Our Case Number: ABP-316119-23

Re: DART+ South West Electrified Heavy Railway Order - Hazelhatch & Celbridge Station to Heuston Station, and Hesuton Station to Glasnevin  
County Dublin and County Kildare

**Re: DART+ South West Electrified Railway Order 2023**

From the information provided it appears that there will be impact on 8 Woodfield Avenue, which would involve the acquisition of a sub-stratum of land underneath the back garden. However, it is not known what the depth may be and greater detail of impact is not known from the information provided within the Railway Order.

Figure 5-66 Cross Section at Ch 11+000 - Inchicore - Facing West

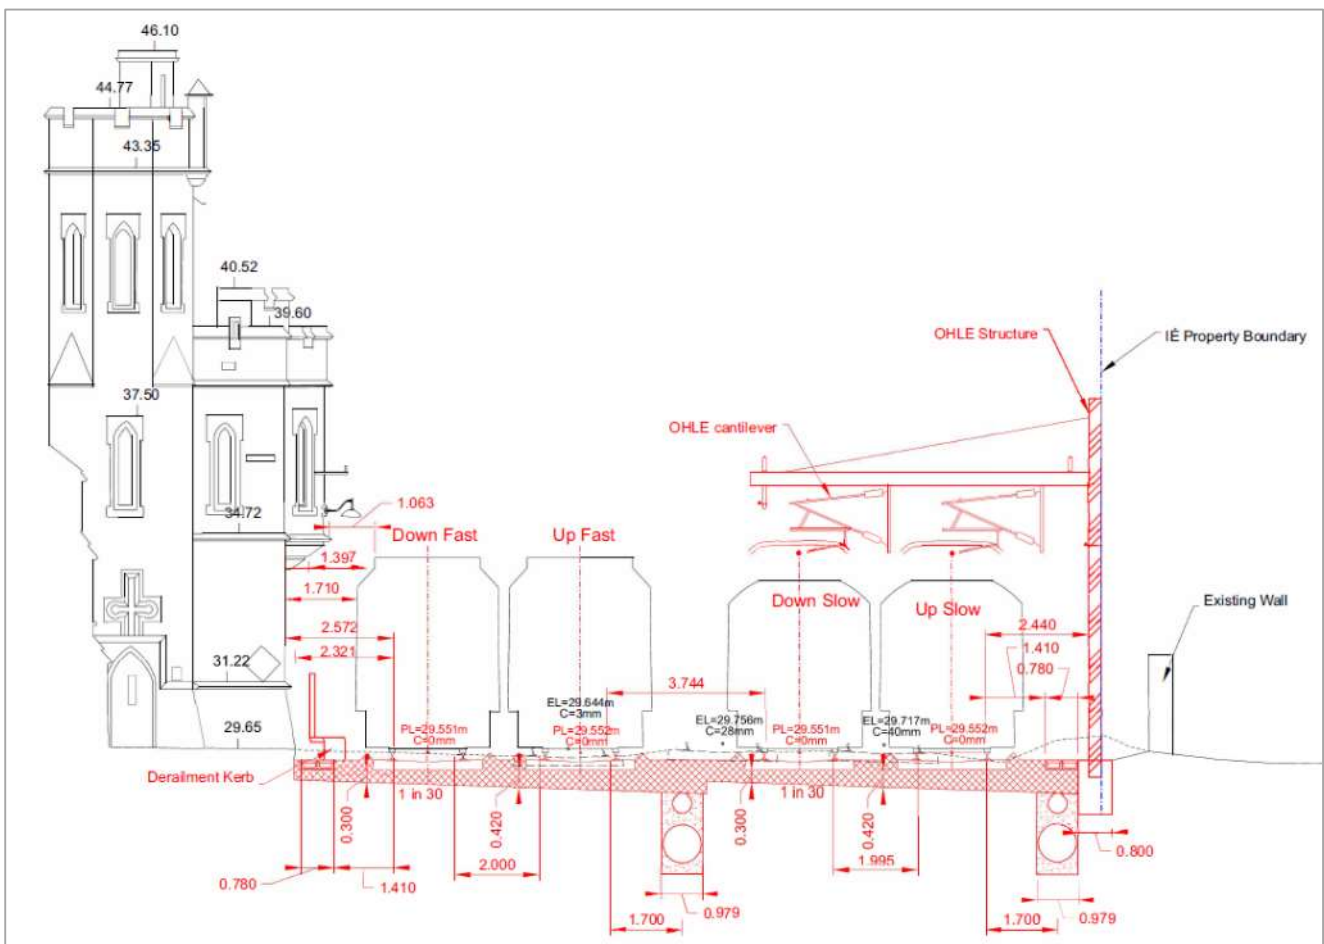
- Impact on my property No 8 Woodfield Avenue
- The ground anchors detailed in the railway order could potentially obstruct future development or damage existing structure within garden adjacent to the boundary of the property as the depth is not clear.
